Please add PCD File No. P-225

Memorandum

To: Elizabeth Nijkamp
Engineer Manager, El Paso County
From: Brian Horan, PE
Date: April 11, 2022
Re: **Constitution Storage: Traffic Memorandum
El Paso County, CO**

Figure 3 – Police Accident Data Map 2016-2022

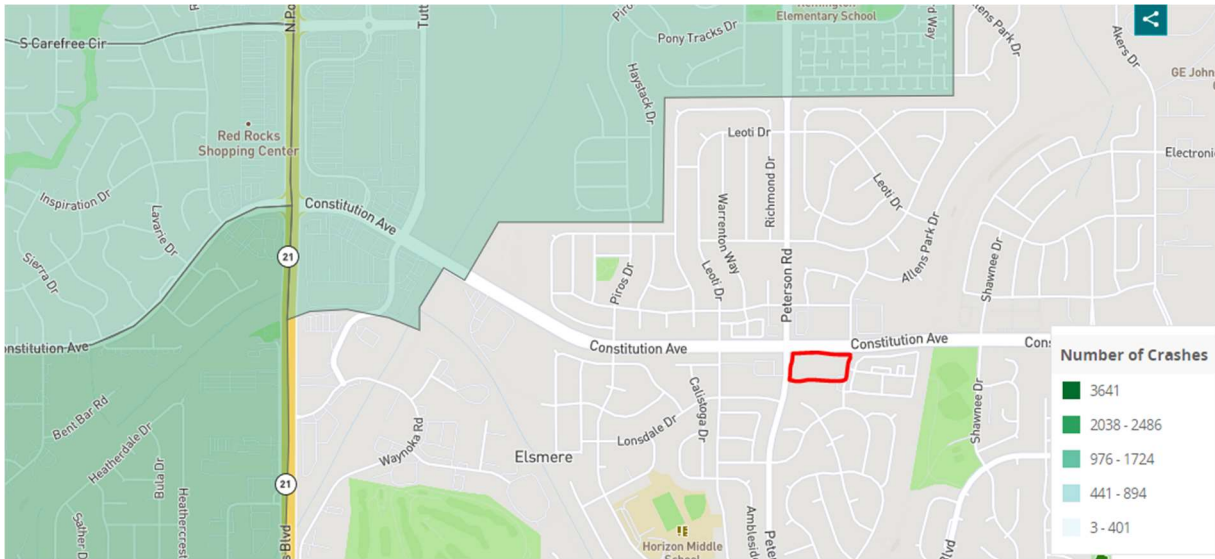
Provide discussions for the proposed access on Peterson Road that justify the location of the access. From the EA meeting: "The TIS should look at the accident rate at this intersection. We would anticipate that the TIS would show us how you can have a restricted movement at this location and provide a safe street for all existing and turning traffic. All of this is then contingent upon a plat amendment being completed after a design has been justified through a TIS and conceptually approved by the County. Please include an autoturn exhibit for Peterson access." Provide an analysis on the crash history data for the intersection.

**Attachment I**  
**Site Plan**  
**Synchro Reports**

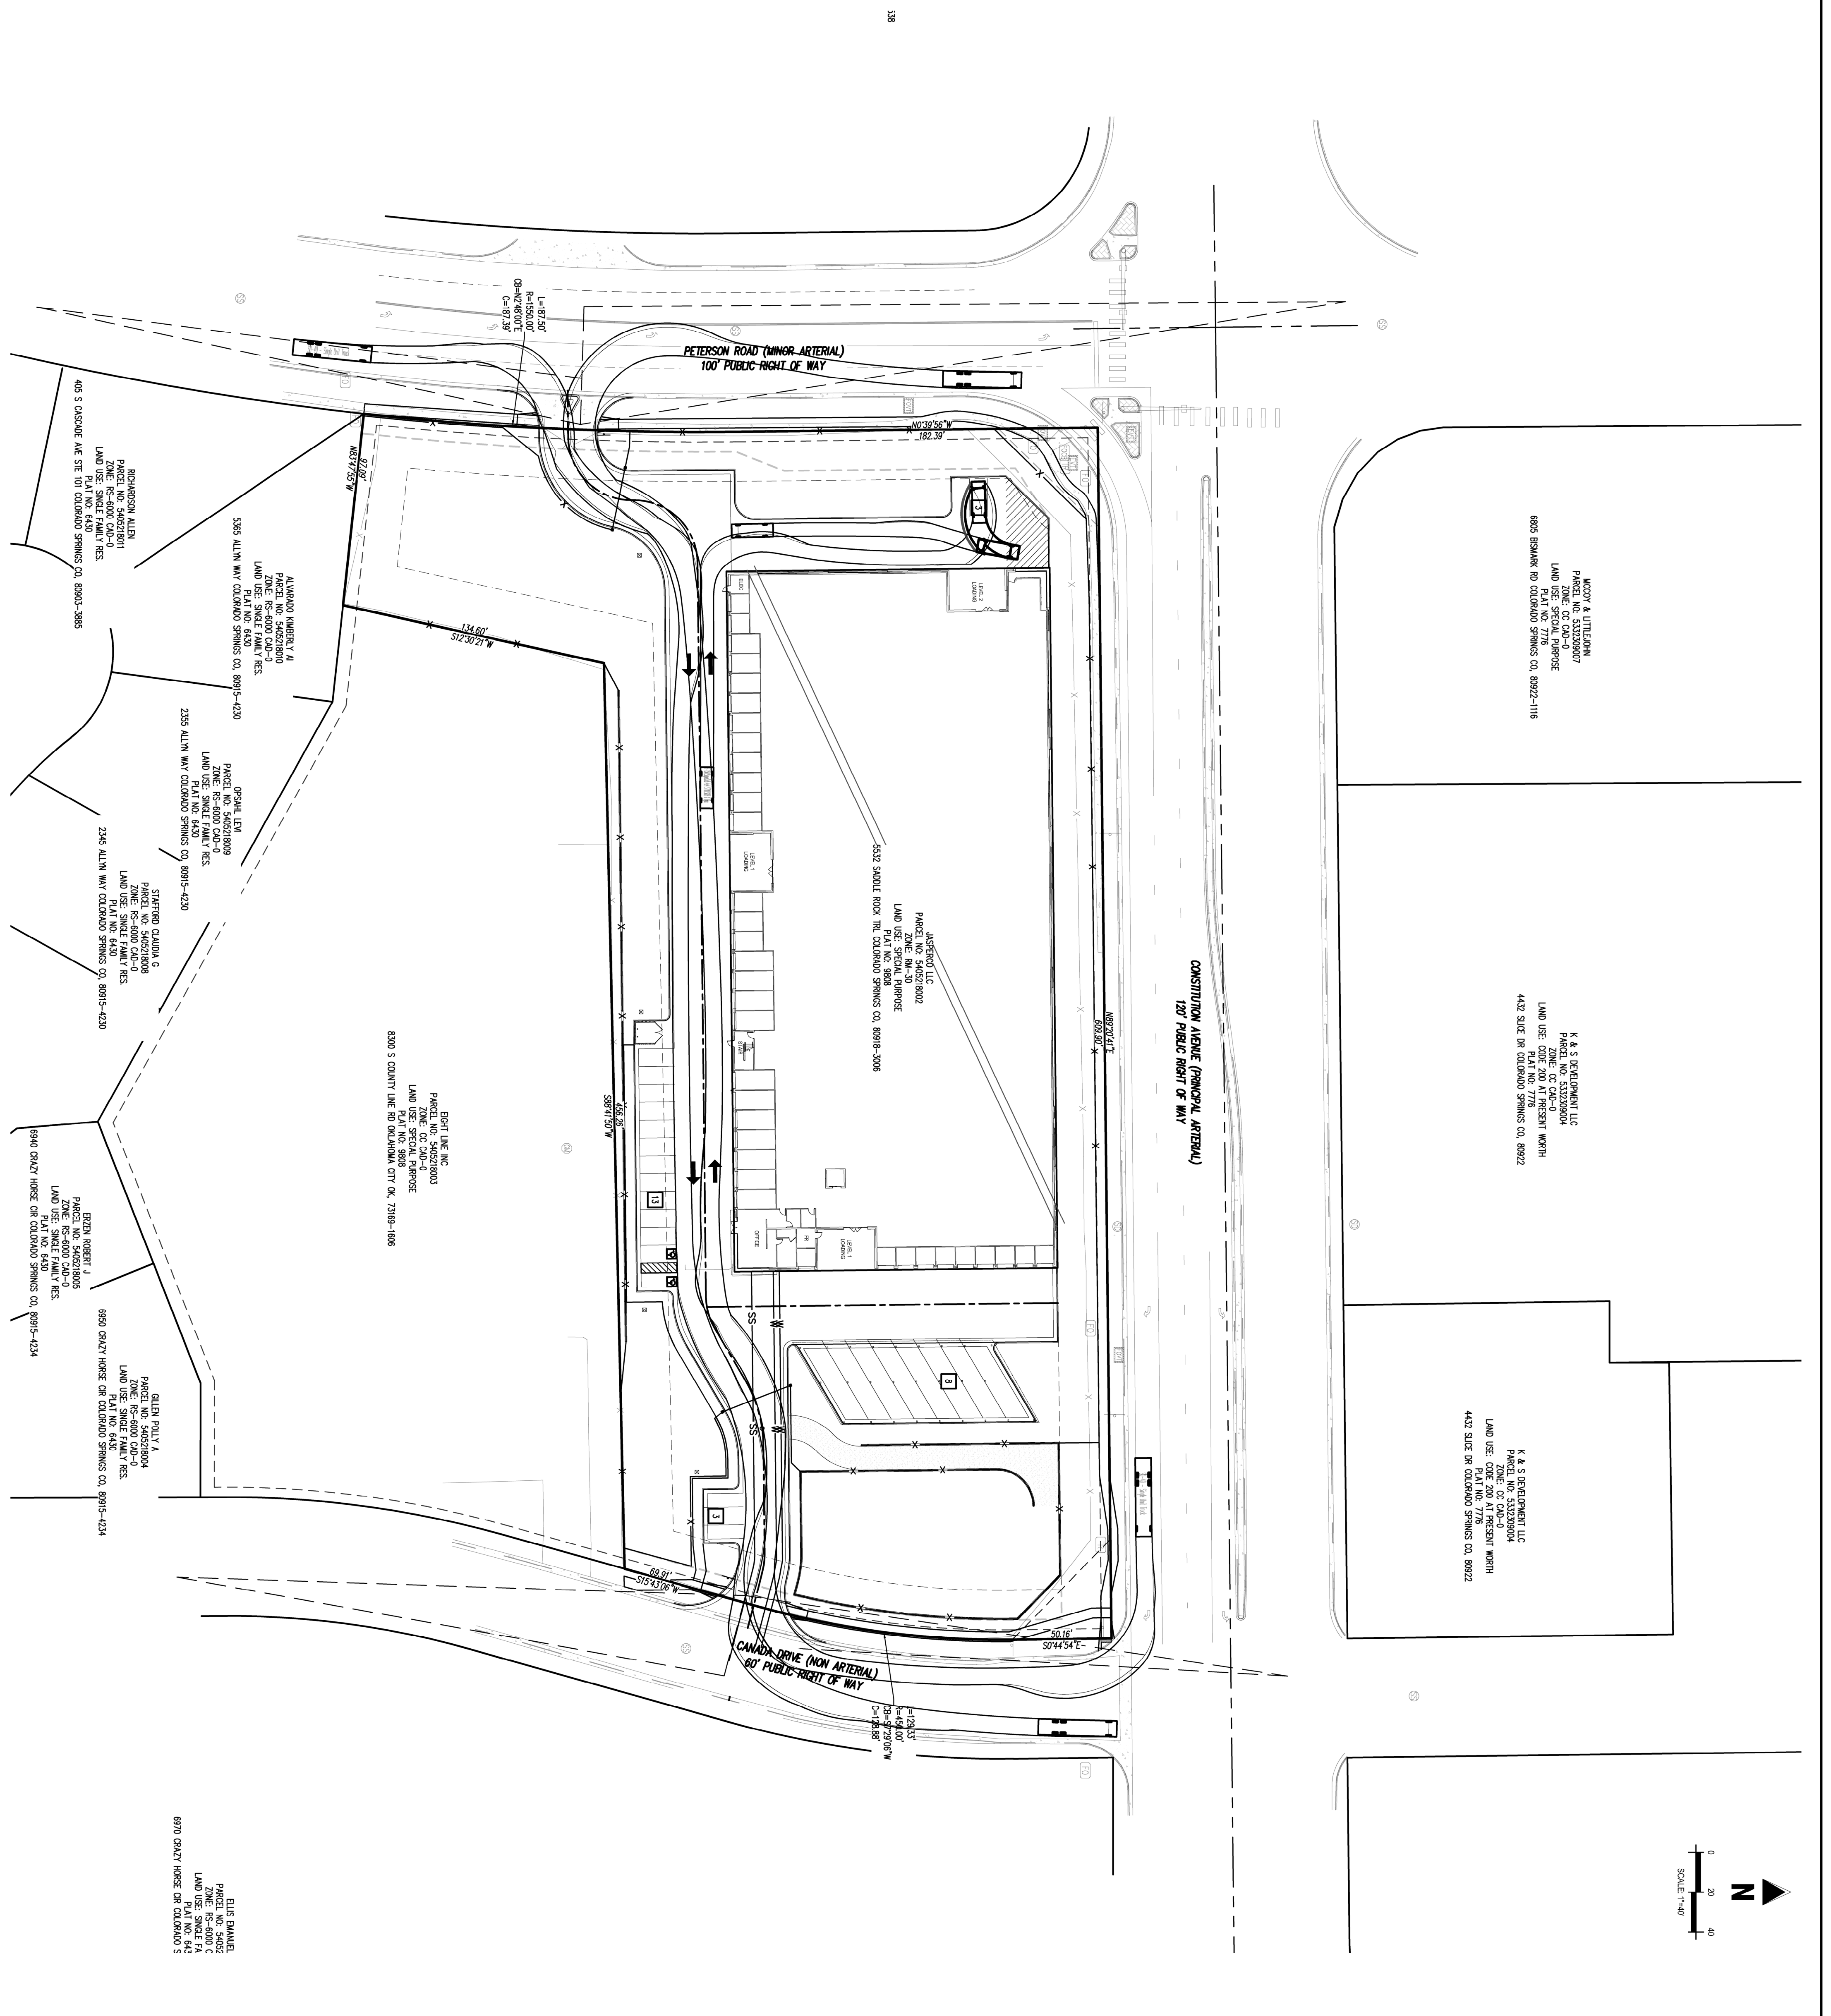
Access to Peterson Road is not allowed per the plat. A deviation request is required to be submitted and approved. Please find the deviation request template in the file attached. The TIS should look at the accident rate at this intersection. We would anticipate that the TIS would show us how you can have a restricted movement at this location and provide a safe street for all existing and turning traffic. All of this is then contingent upon a plat amendment being completed after a design has been justified through a TIS and conceptually approved by the County. Please include an autoturn exhibit for Peterson access. The deviation request should be signed and stamped.
